## **SCOPING OPINION:**

# **Proposed Weston Marsh to East Leicestershire**

**Case Reference: EN0210007**

**17 December 2025**

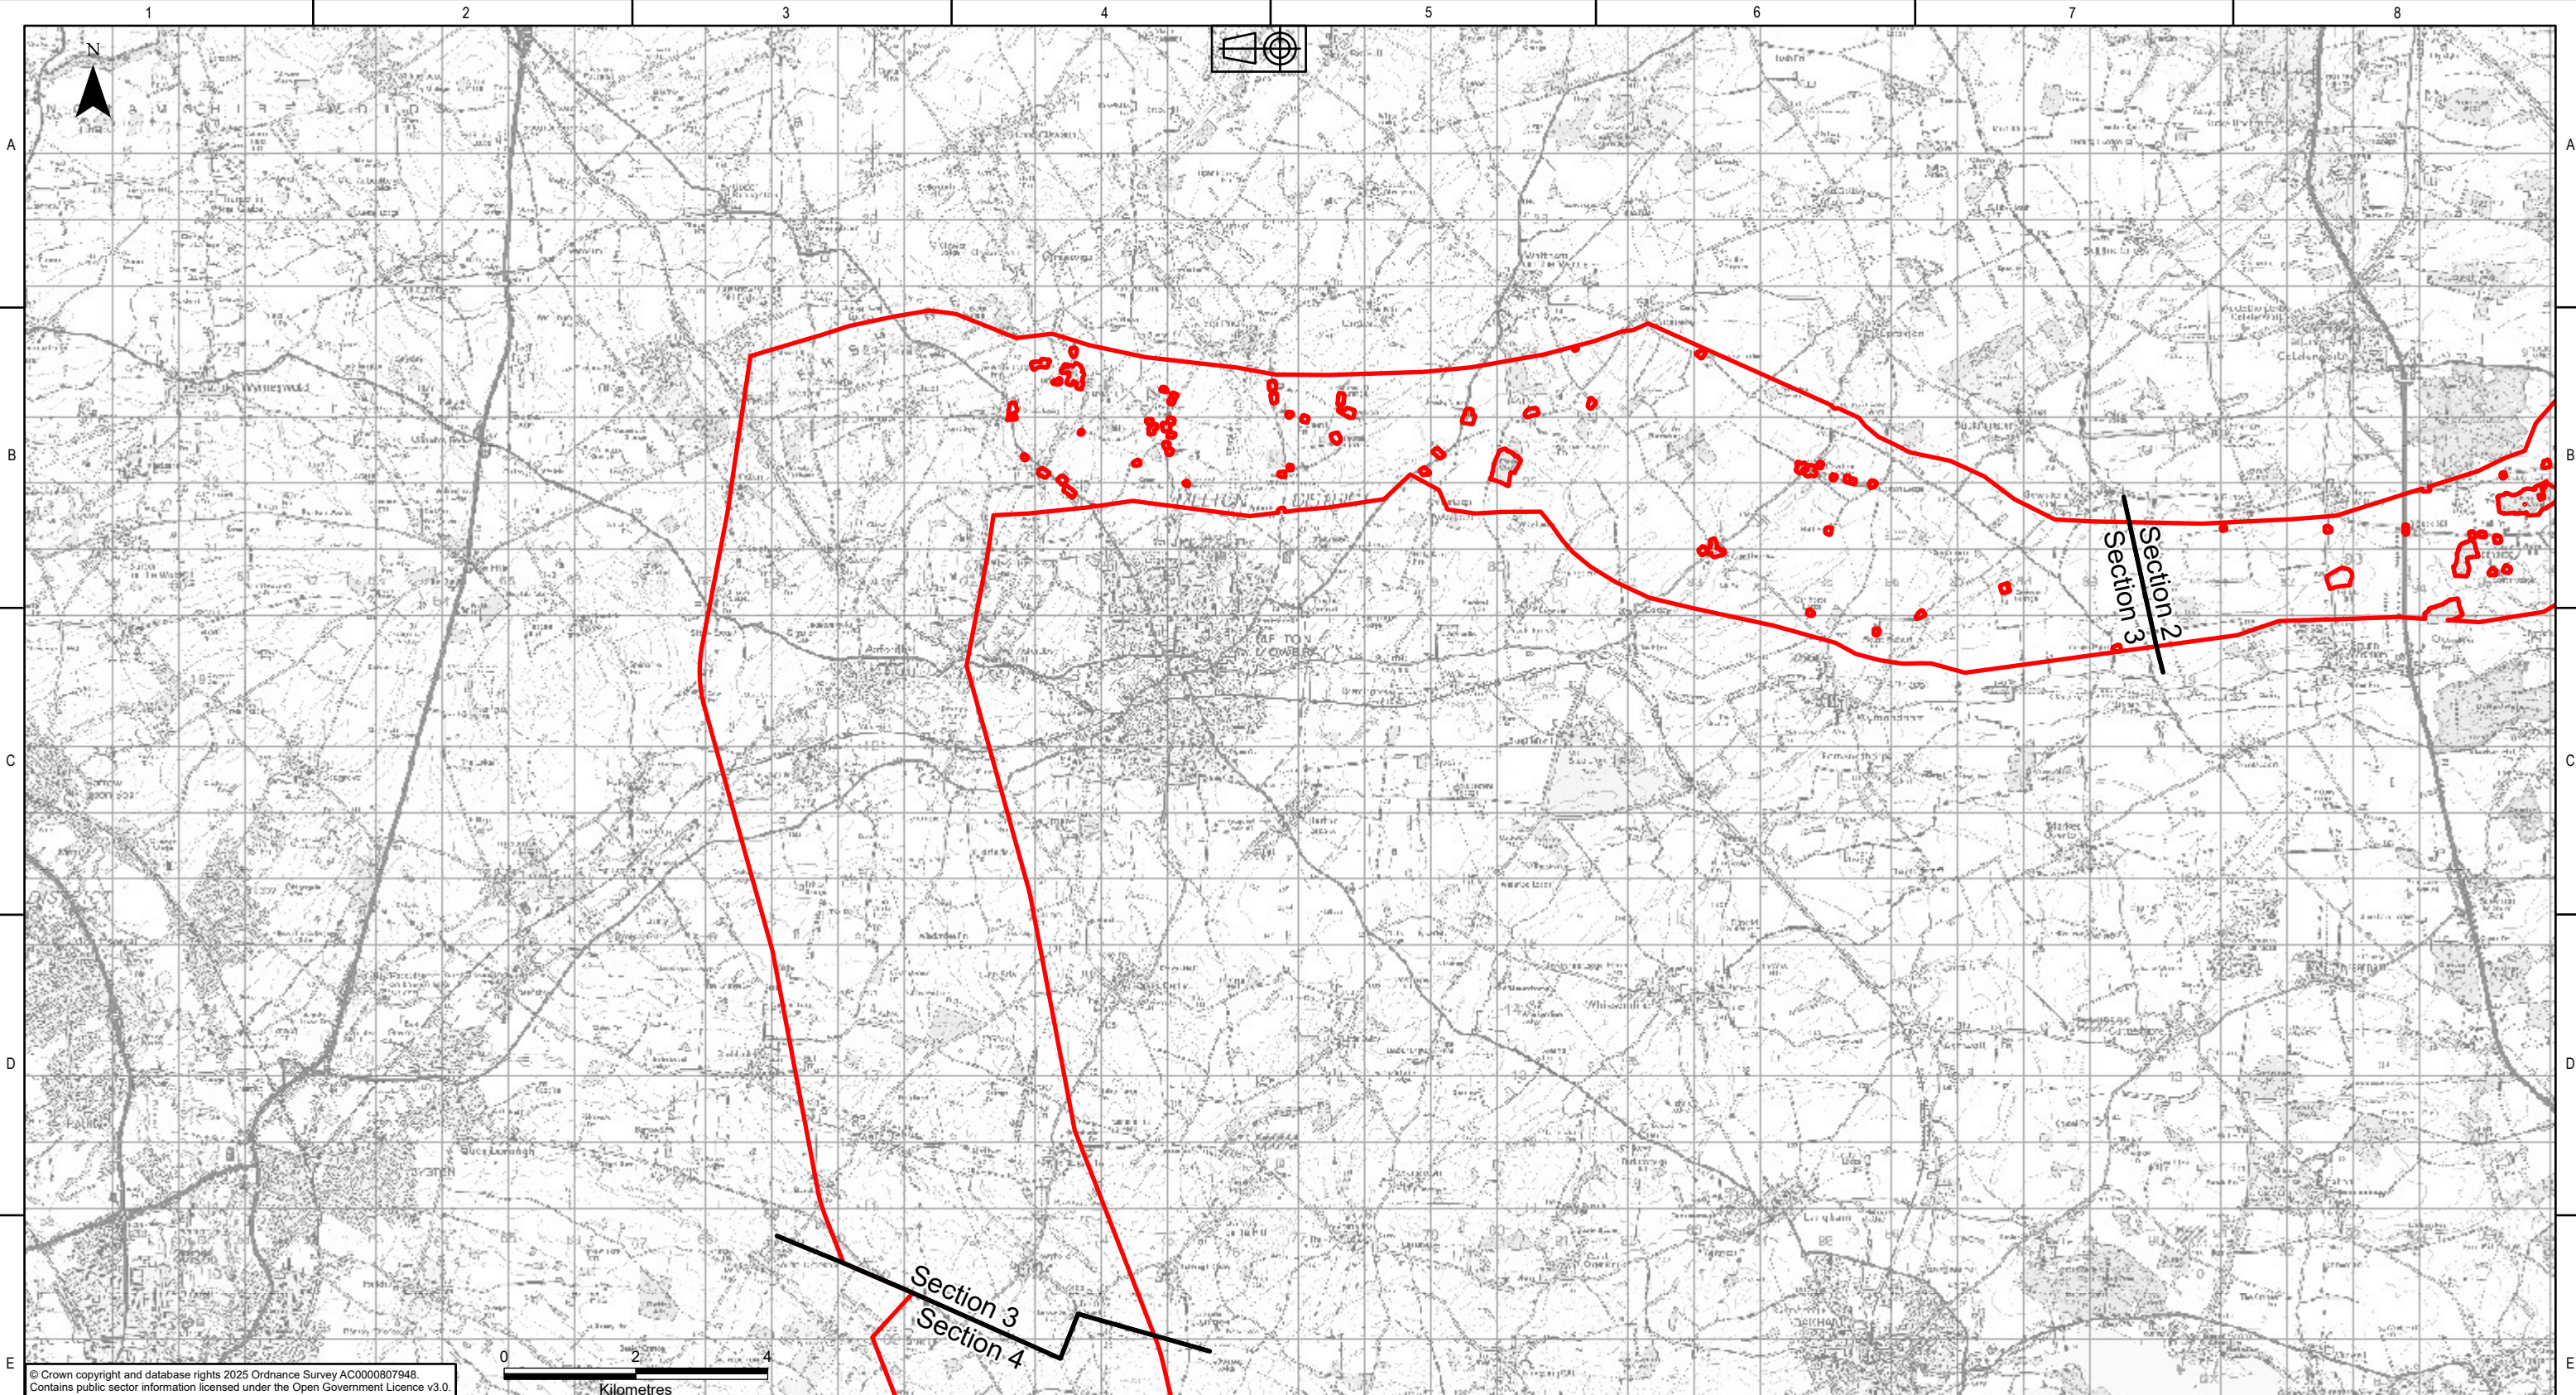
212	Figures	Legibility	<p>The Inspectorate notes that there are a number of figures, which due to scale are difficult to interpret and it is not possible to read place names (for example figure 1.2 and 3.1). The ES should ensure that all figures are clear and legible in order for the information provided in them to be easily interpreted.</p>
